PLANNING WORKSHEET 11 – DELEGATED / PCG REPORT - GENERAL

Application Ref.	22/00696/FUL	
Site Address	Land Adjacent To The Cottage Mill Lane Normanton On Trent Newark Nottinghamshire	
Proposal	Erect Dwelling With Detached Garage and Construct New Access	
Case Officer	Jamie Elliott	
Decision Level	Delegated following referral to PCG	
Recommendation	GRANT	
Reason(s) for PCG referral	Objections received from Local Residents.	
PCG Sign off and date	 8 th August 2022	
Signature		
Date		
Case Officer	JE	04/08/2022
Authorised signing Manager		8 th August 2022

SCALE 1:100 1:200 DATE MAY 2021 DRAWING No. 1867.A.1c

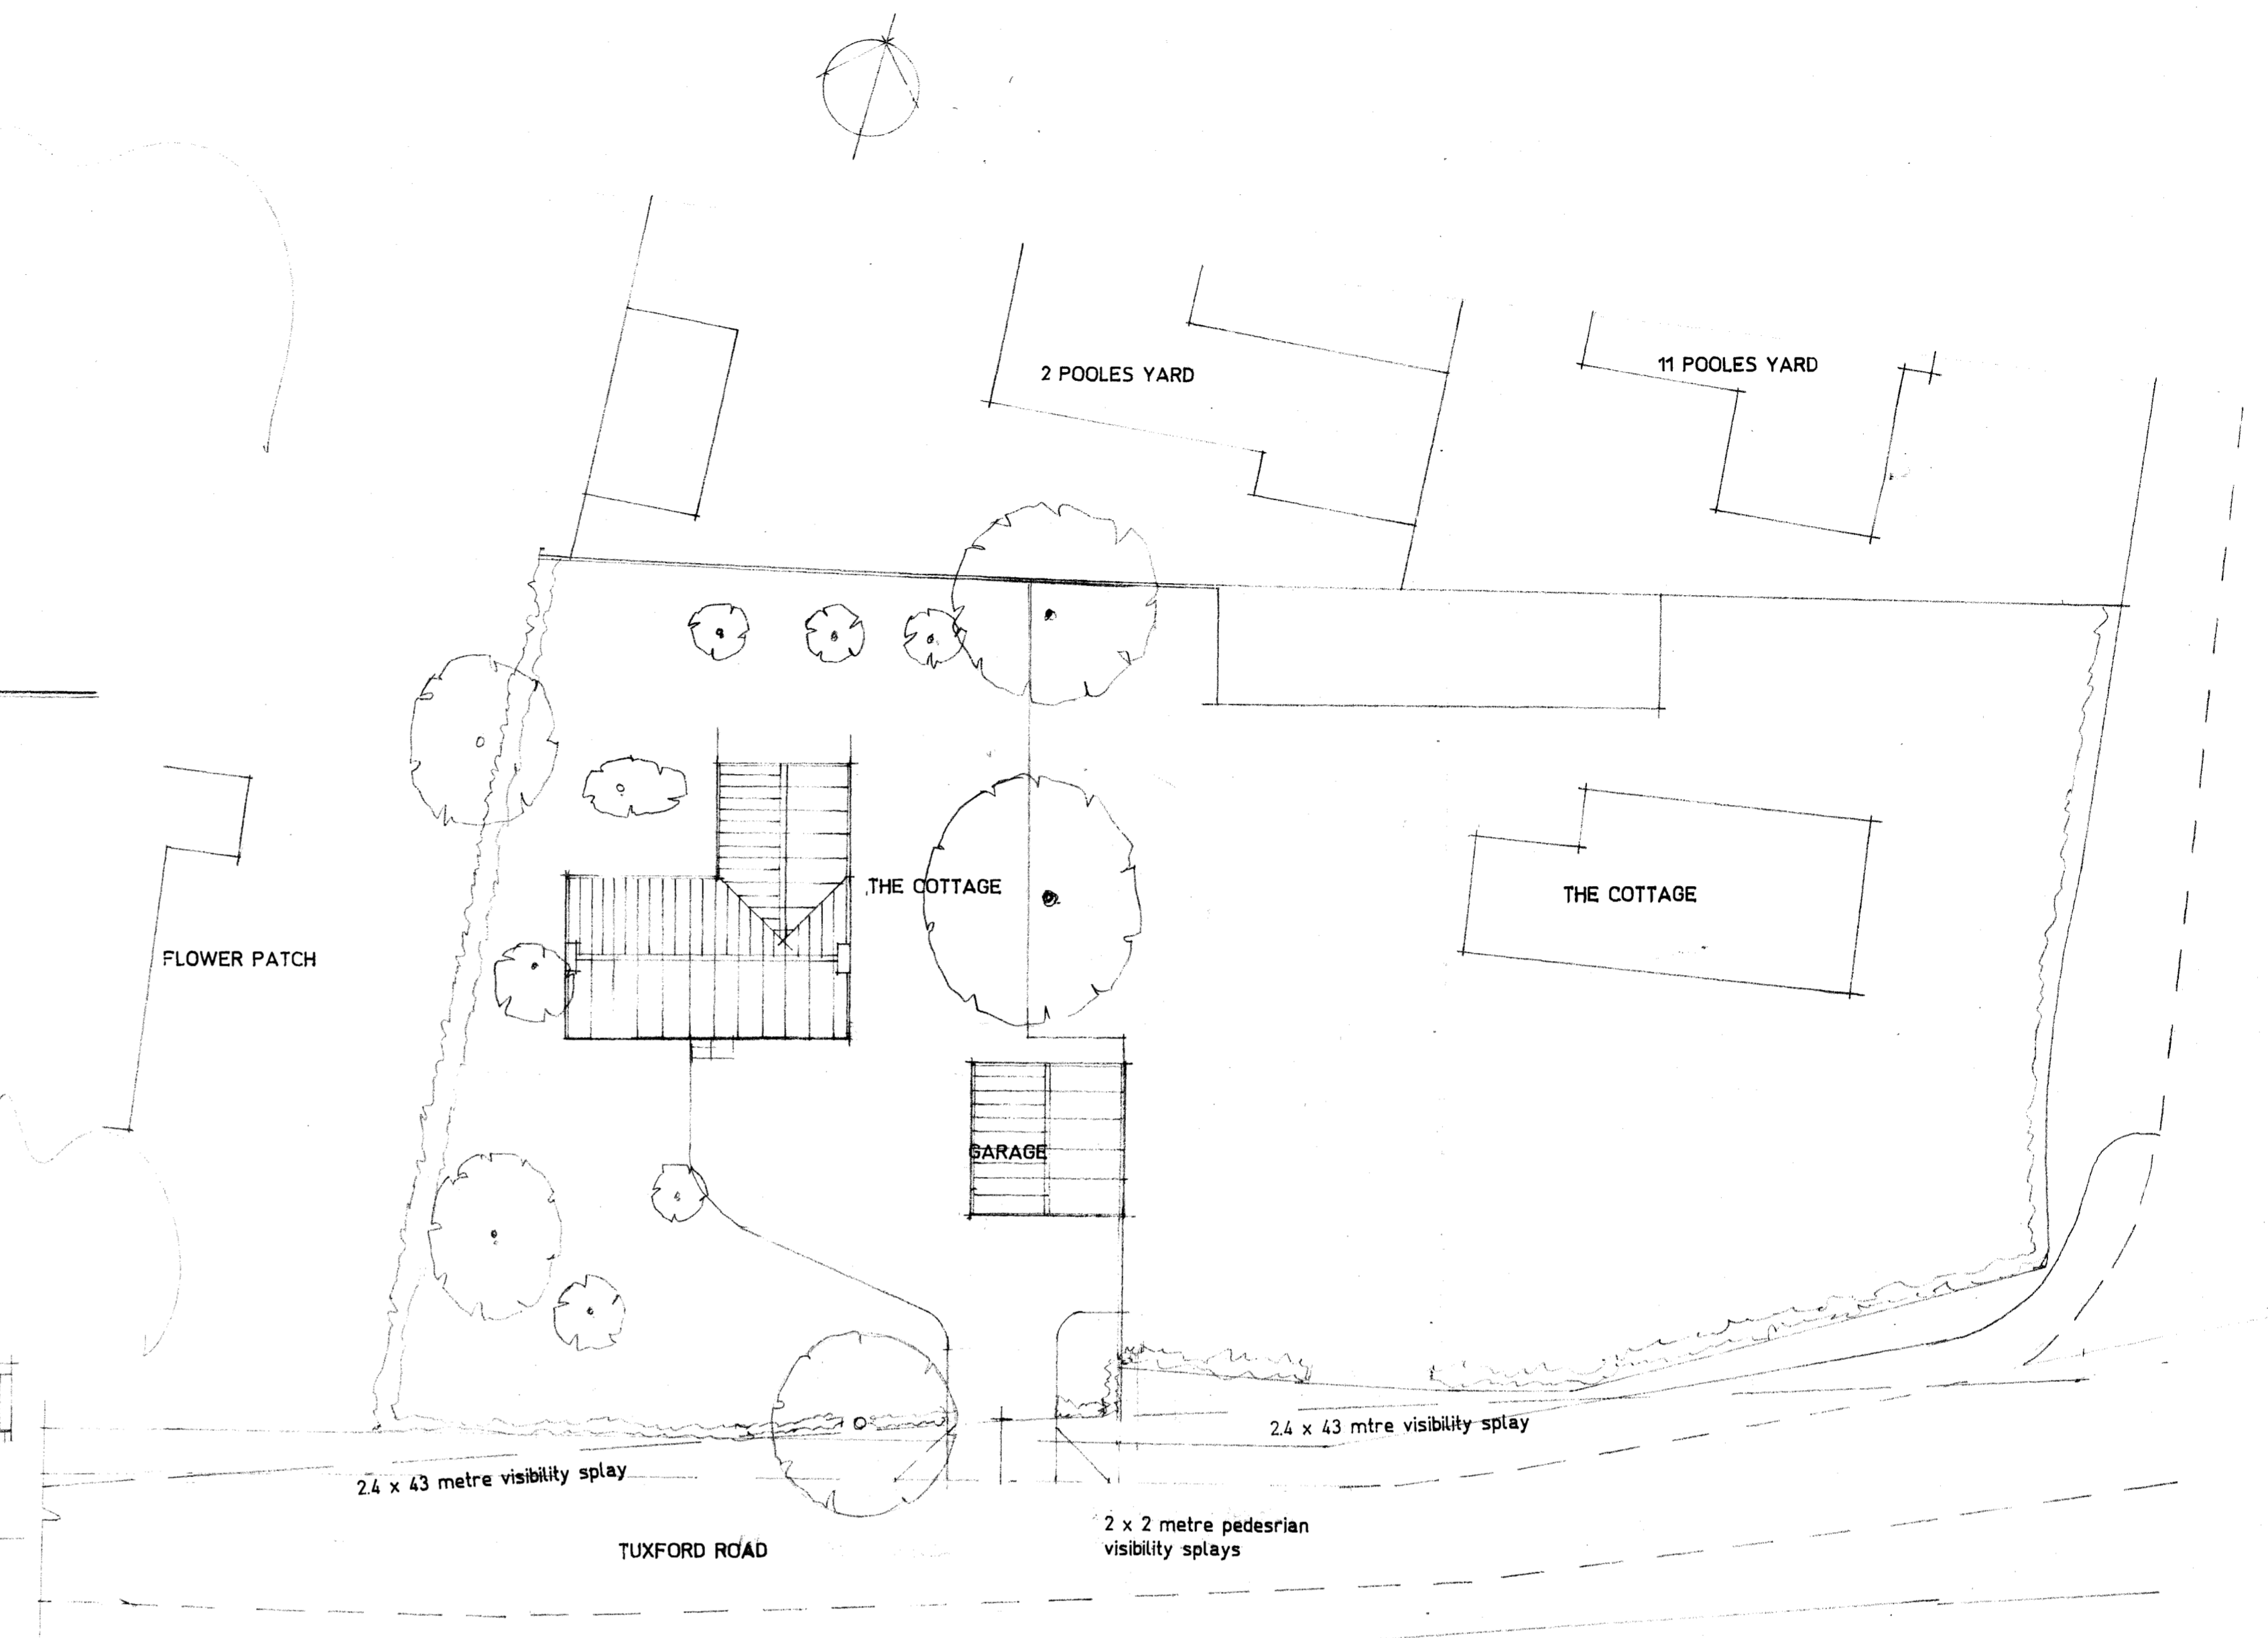
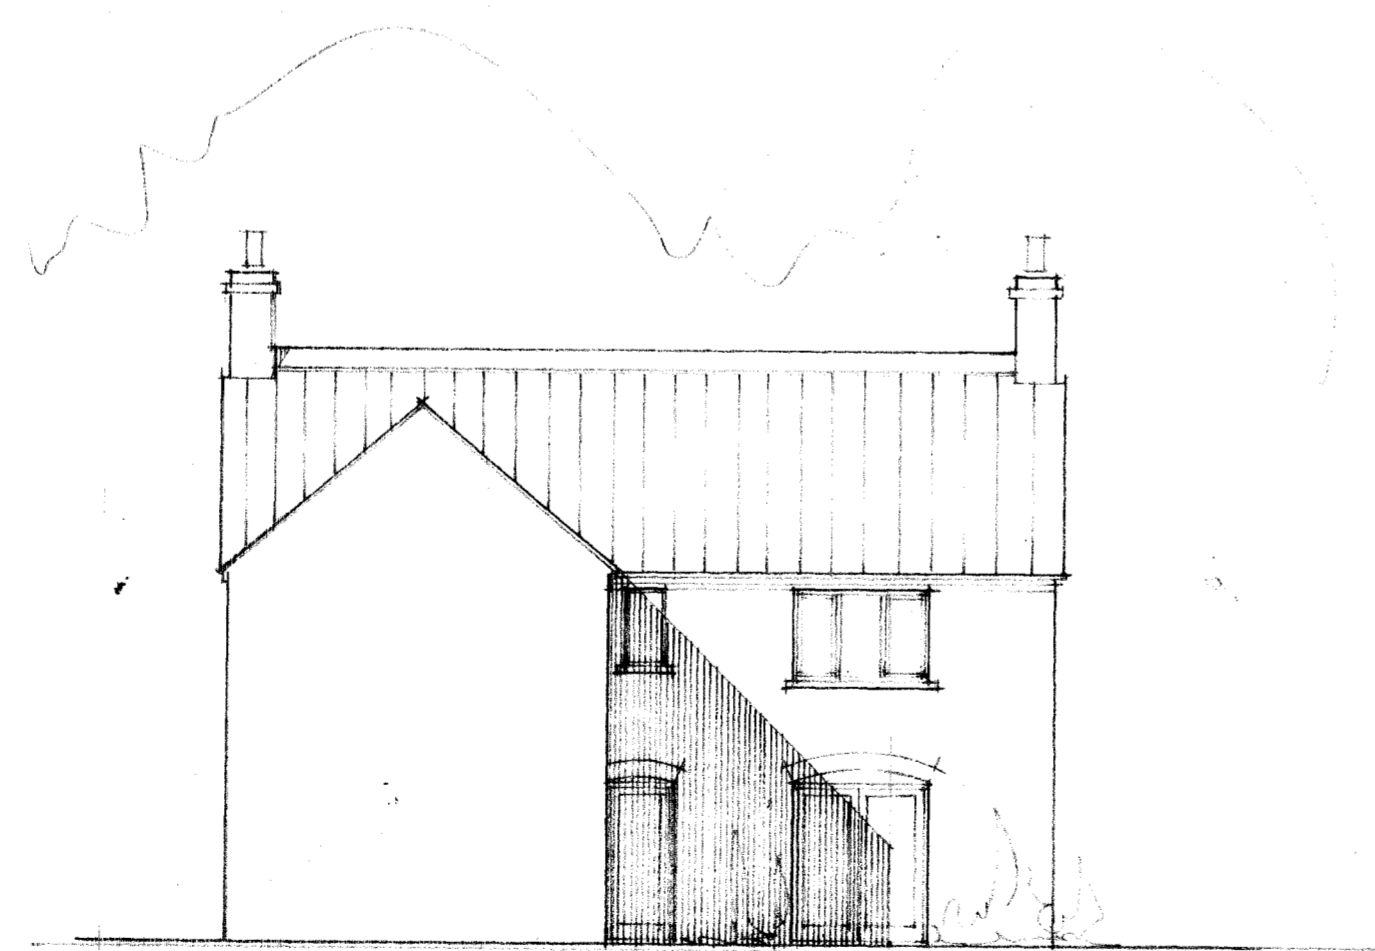
The design of the dwelling and garage appear to be generally acceptable. However further clarification is needed in regards to materials. The application specifies that the proposed external finish will consist of 'Red Brick'. Conservation would need to know the specific type/model of the brick to be used in order to properly assess the scheme. There is also no mention of a proposed brick bond, which again would need to be clarified.

Note that a standard stretcher bond would not be supported, and instead a historic brick bond should be adopted such as 'Flemish Stretcher Bond', which appears to be the brick bond used on the adjacent listed Cottage.

Similarly, the proposed external finish for the roof is denoted as 'Clay Pantile'. Again, Conservation would require further clarification as to what brand and type of clay pantile is to be used. Conservation would recommend using a non-interlocking clay pantile.

For the reasons outlined above and subject to conditions securing facing materials

and brick bond, it is considered that the proposal would help to preserve the setting of the surrounding designated and non-designated heritage assets.

SCALE 1:50 DATE MAY 2021 DRAWING No 1867.A.2

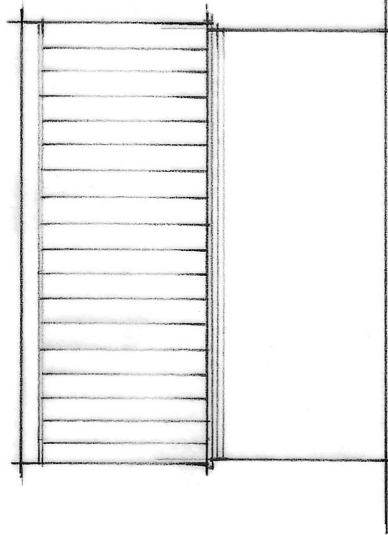
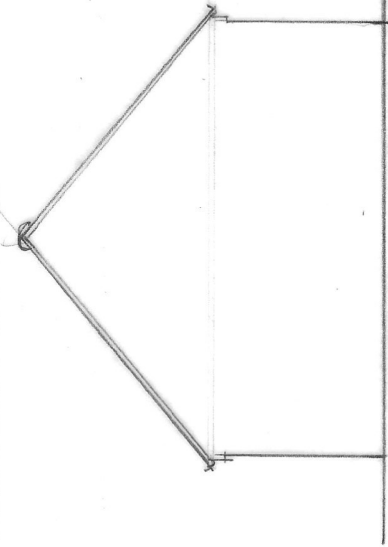
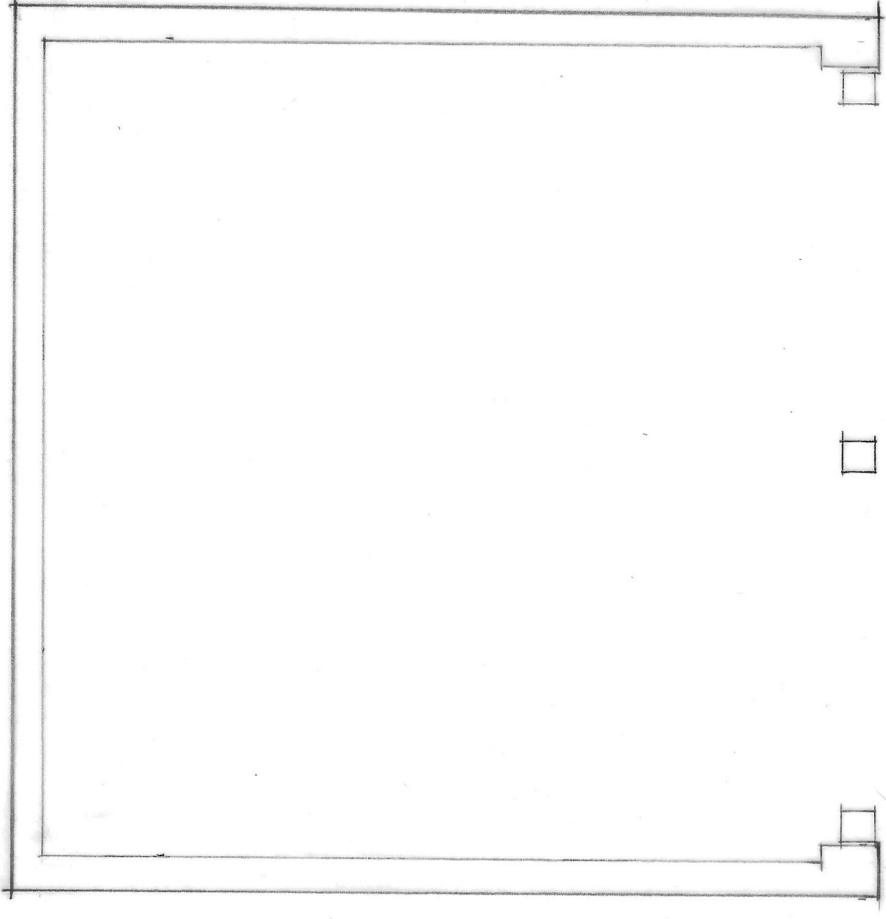
The design of the proposed garage range appears to be acceptable. The form of the building is simple, comprised of a single unit consisting of an external brick façade, open-front elevation with elements of timber framing and a gabled clay pantile roof. This design is reminiscent of historic agricultural cart-sheds, and as such is considered to be appropriate within the context of the surrounding built heritage. However, there are several outlying details in regards to materials which require further clarification.
